April 23, 2024

**Re: Raising Cane's Restaurant  
SWC of St Joseph and Coors  
Site Plan  
Engineer's Stamp 4-18-24 (G11D067D)**

Subject: Raising Cane's Restaurant SWC of St. Joseph and Coors Site Plan

ACCESSIBLE PARKING DETAIL
N.T.S.

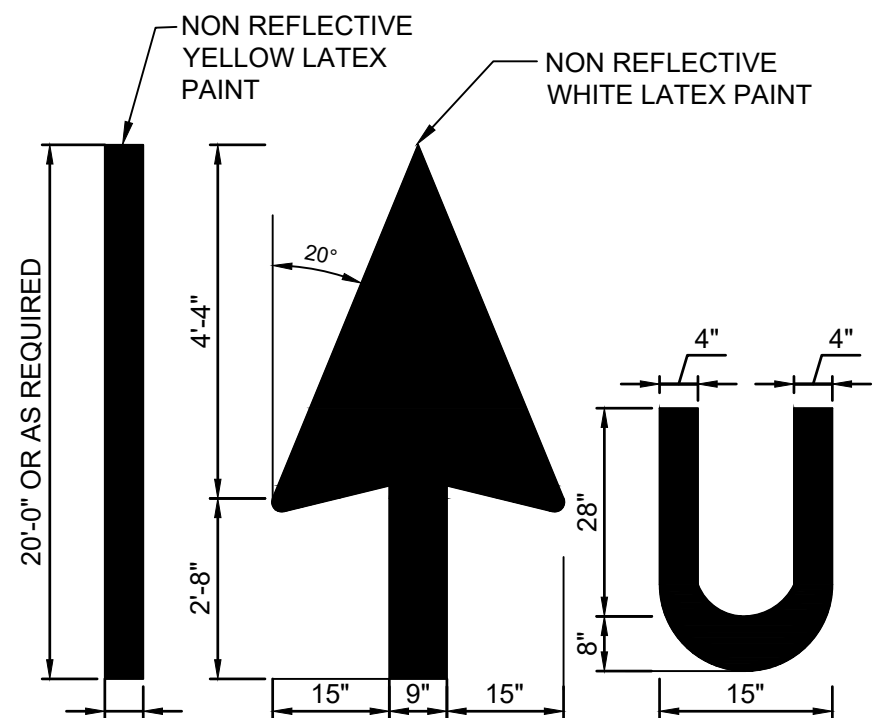
Comment 10: Accessible aisle stripes should be blue rather than white.

Comment 11: The accessible aisle detail has the non-van space as 9.0' wide, whereas the site plan shows it as 8.5 feet wide.

**Response:** *The accessible parking detail on sheet C5.2 has been updated to call out 4" solid blue latex painted stripes. The accessible parking symbol detail is still specifying white.*

**Response:** *The accessible parking detail on sheet C5.2 has been updated to reflect the 8.5' dimension shown in plan view.*

SITE KEYNOTE PLAN

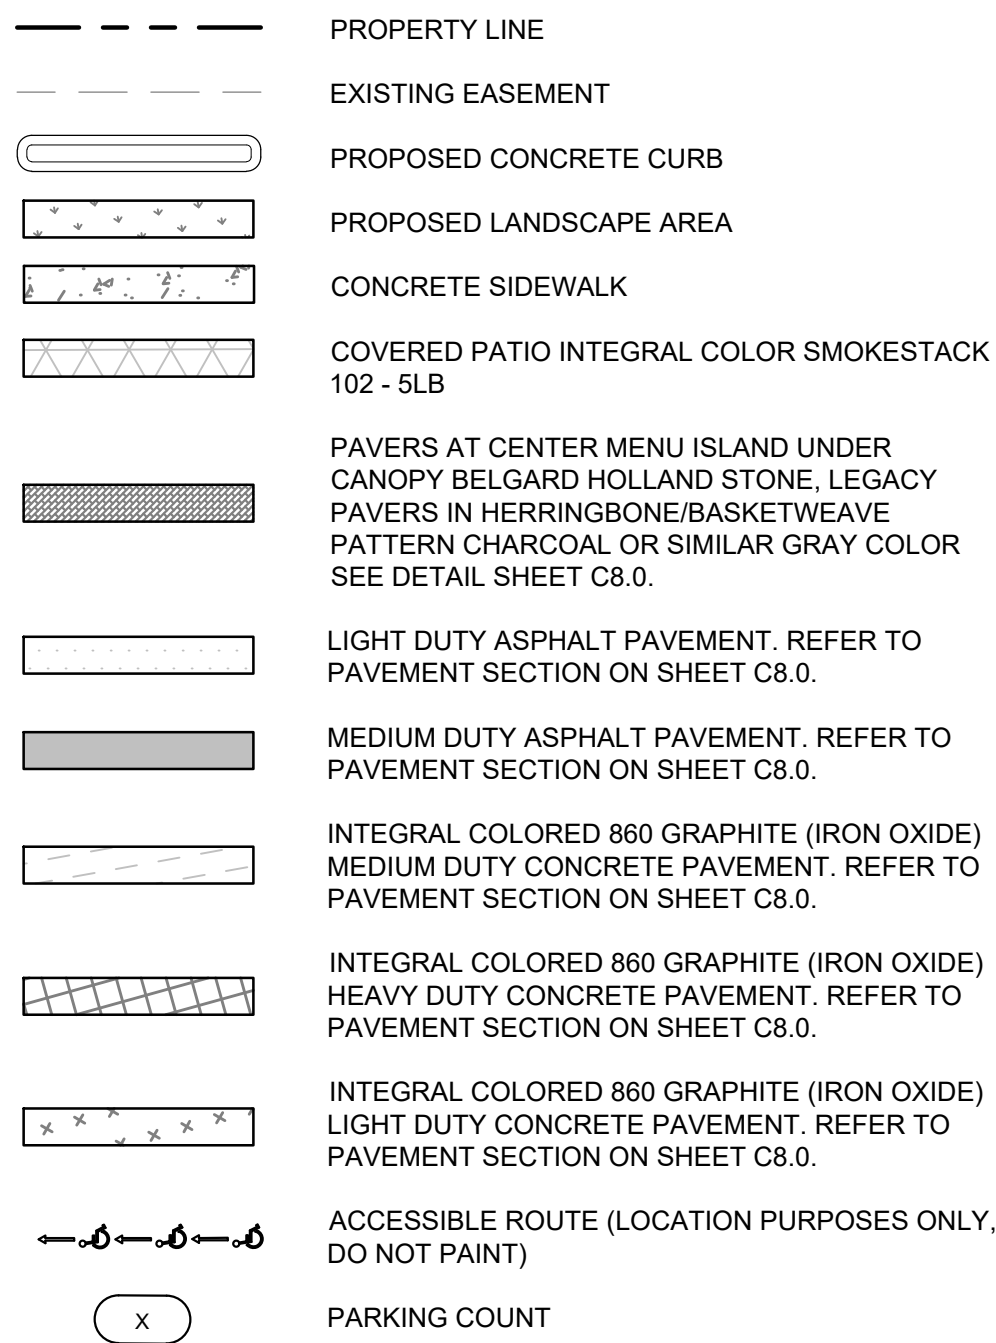
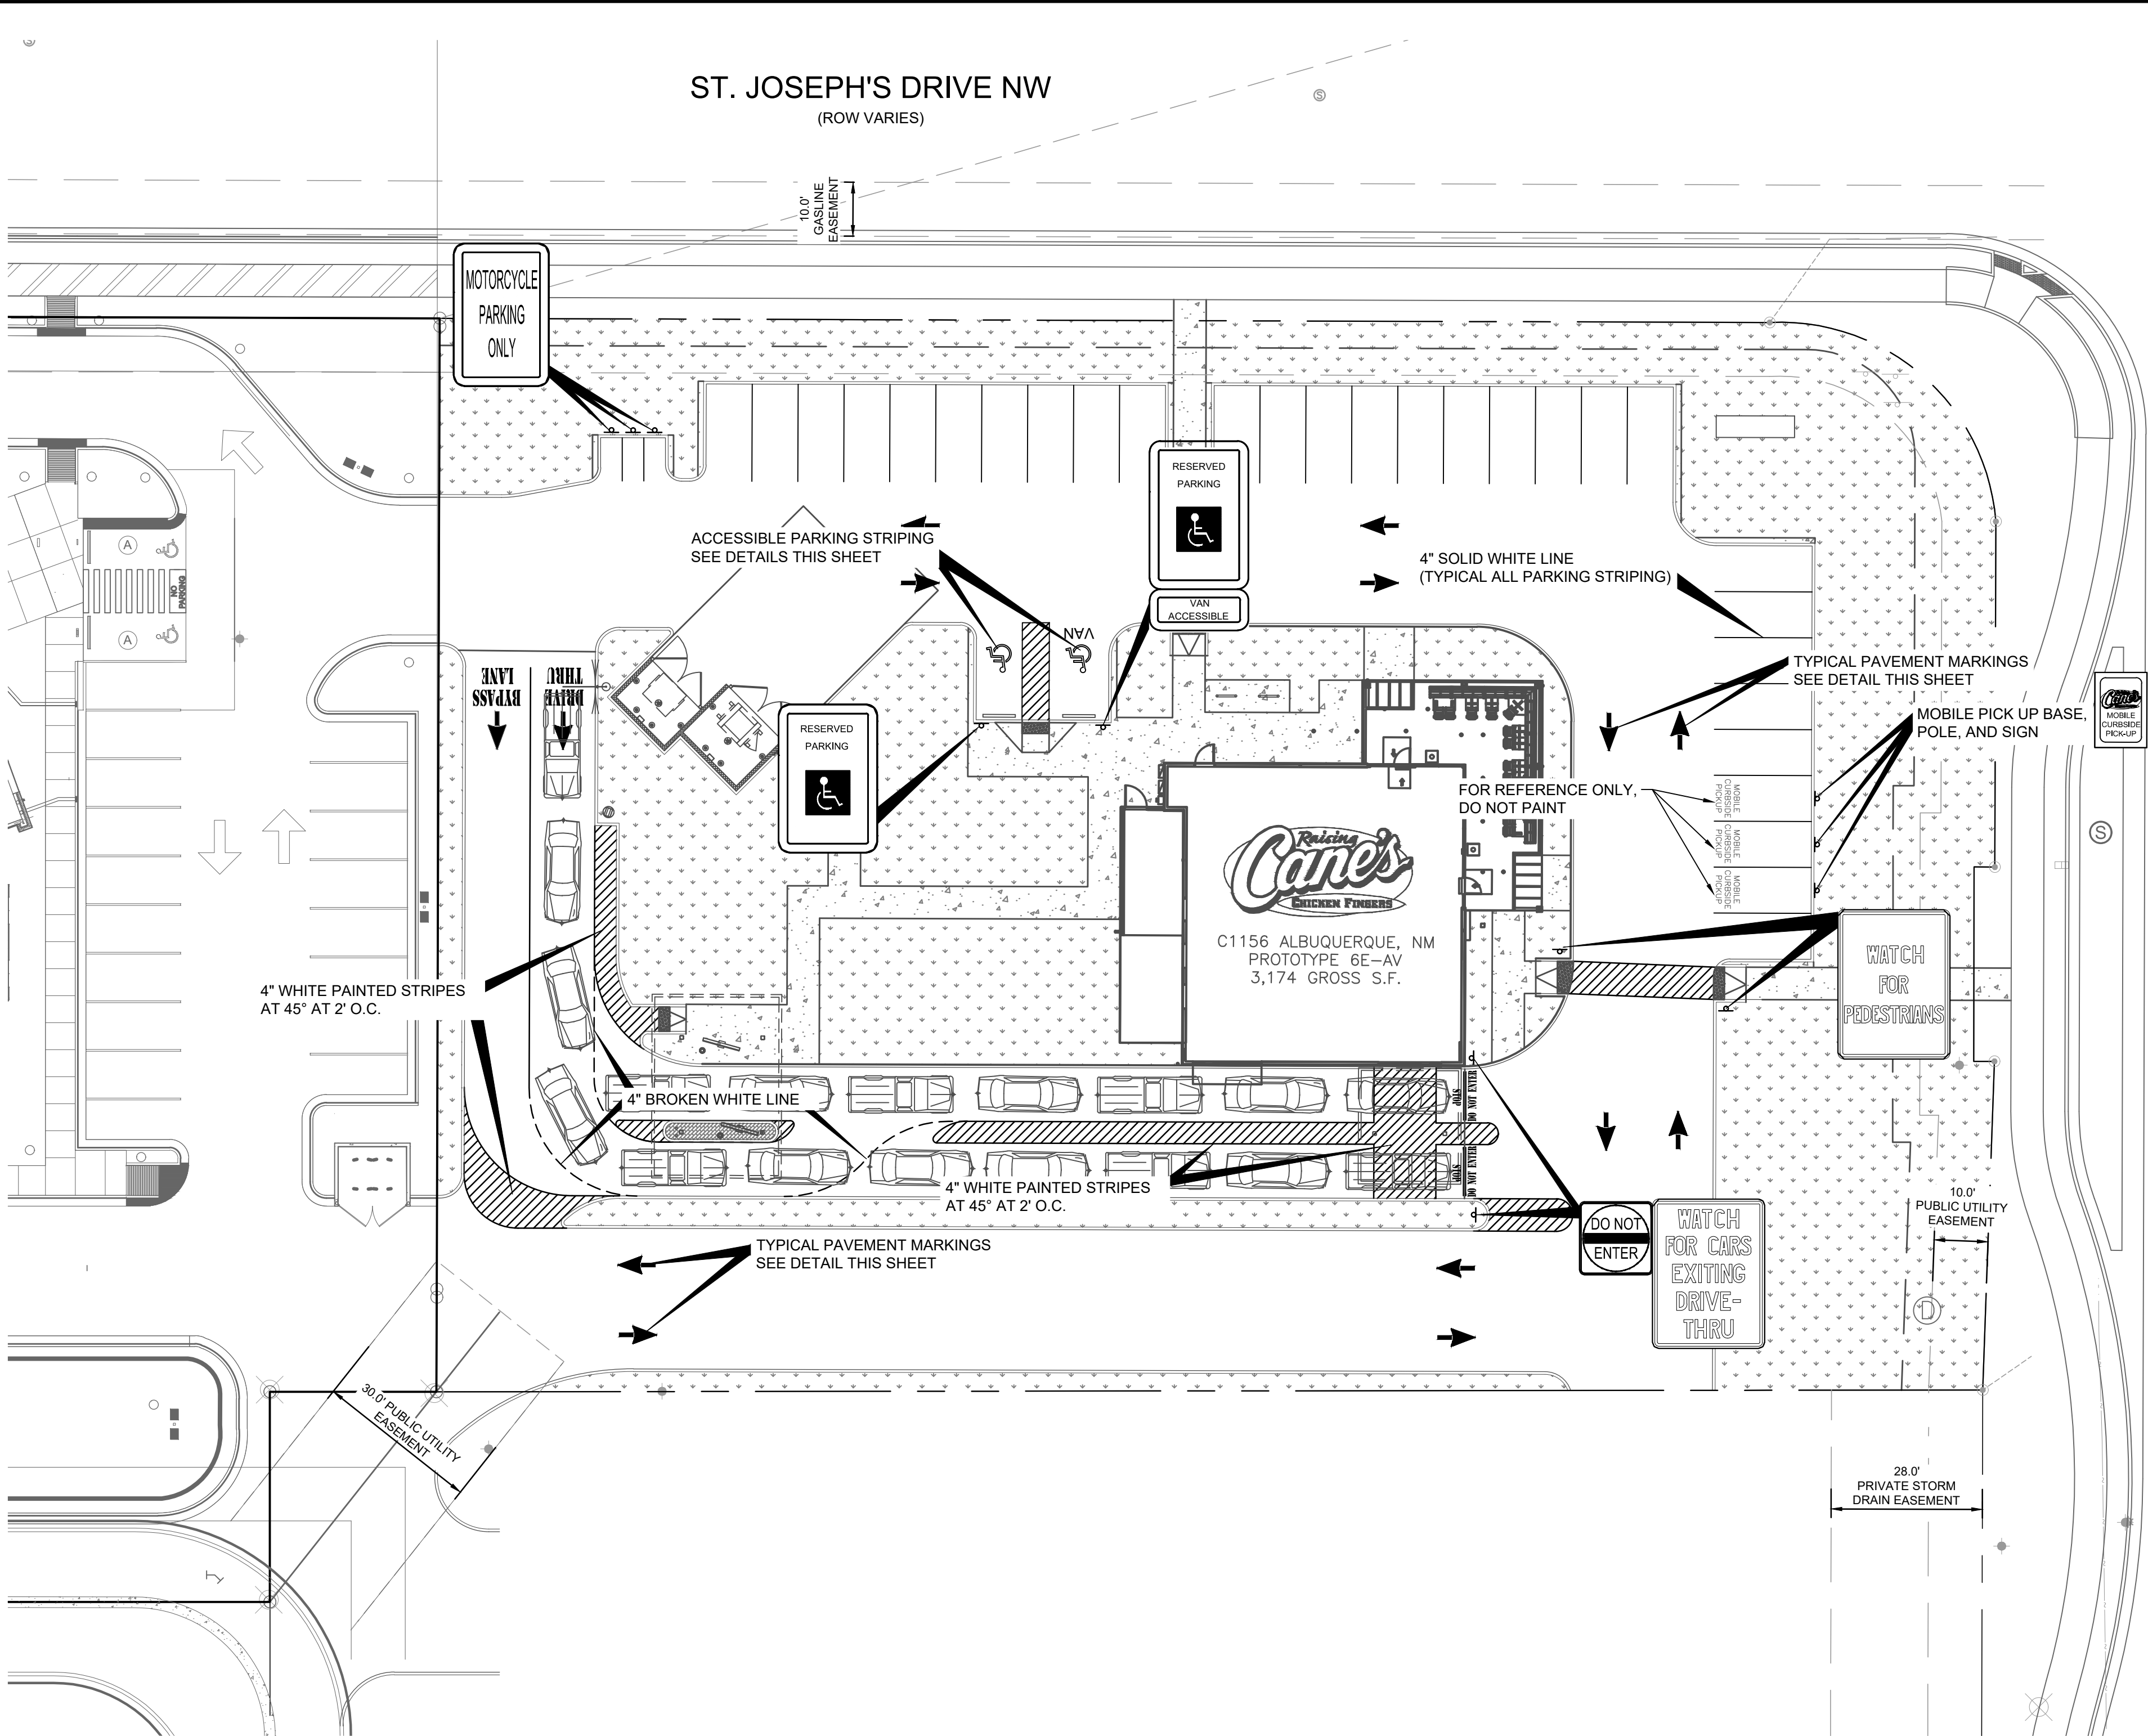
Comment 1: The entrance/exit at the private circulation road appears to have vehicles entering and exiting from three businesses with the Raising Cane's entering/exiting on a 45 degree angle at a 90 degree bend in the road. It is not clear how this intersection will function. The 2024 02 06 Oxbow Composite Plan Model (1)-Developer.pdf shows a better intersection as the Lot 6 entrance is 100 feet or more south of the 90 degree bend. This issue was discussed with Sydney (sp?) at Kimley Horn and we discussed showing the curb line across Lot 6 per the 2024 02 06 Oxbow Composite Plan Model (1)-Developer.pdf.

Comment 3: It appears you are proposing ½ or so of a landscape area along the southern boundary. The 2024 02 06 Oxbow Composite Plan Model (1)-Developer.pdf shows parking spaces in this location. Please coordinate with the project on Lot 6 or the Developer to figure out what is to be built in this area.

Comment 5: Provide a detail/keyed note for the bicycle racks. Contractors regularly install racks that don't meet City code. The inverted-U style meet our code as an example. Please let me know if you like more information on rack requirements.

Comment 6: The drive-thru lanes are to be a minimum of 12' wide. The minimum inside diameter radius is required to be 25 feet. Provide the three radii at the bend in the drive-thru. The radii can be reduced to 15', if the lanes are 14' wide.

Comment 7: The minimum stacking requirement is 12 cars at 20' each. It appears the stacking is 10 cars in the drive-thru lane. The length of a car is not provided. It appears the bypass lane is a drive-thru lane due to the location of the order board. How does the bypass lane function?

Comment 8: The broken white lines in the drive-thru and stacking lanes may be confusing to drivers, but if can show you have stacking for 12 cars at 20' each, it meets out regs.

Comment 9: Please add a note "Broken or cracked sidewalk in the ROW is to be replaced". Landscapers can get carried-away with the skid-steer.

Comment 12: The arrow on the concrete (dumpster pad) should be black rather than white so it is visible. It may help the Contractor to shift the arrows east, so they are both on asphalt.

**Response:** *The entrance/exit at the private circulation road has been revised to remove the additional driveway stub on the east side to lot 6. What is currently shown better aligns with the Oxbow Composite Plan Model.*

**Response:** *At this time, it is Raising Cane's understanding that the future layout of Lot 6 is not yet determined. The proposed curb line on the south side lines up with the current composite plan for*

***Response: Keynote T on sheet C5.0 has been updated to read "proposed inverted-U style bike rack."***

***Response: The drive-thru lanes have been revised to be 12' wide. The radius at the bend in the drive-thru has been revised to be 25' and has been annotated accordingly.***

***Response: The second drive-thru lane after the bend will be used daily. Queuing cars can select either drive-thru lane at the bend to order and pick up their food. The vehicles shown on sheet C5.0 using the single drive-thru lane at the entrance and then breaking into two lanes are considered to be Raising Cane's standard queuing operations that will be utilized daily. The total number of vehicles able to successfully queue is 18.***

***A dimension has been added to a vehicle block immediately south of the building, 20' per vehicle is utilized for design.***

***The bypass lane can be used by customers if 18 cars have already queued and will function as a second full-length drive-thru lane. The curb cut at the southeast corner allows customers to exit the drive-thru lane before ordering if they choose.***

**Response:** *The broken white lines are Raising Cane's operational standard and are utilized if employees need to direct traffic towards one menu board or one pick-up aisle during low volume times.*

**Response:** *Site note #8 has been added.*

**Response:** *The arrows have been shifted to the west so they are not painted across two different pavement types.*
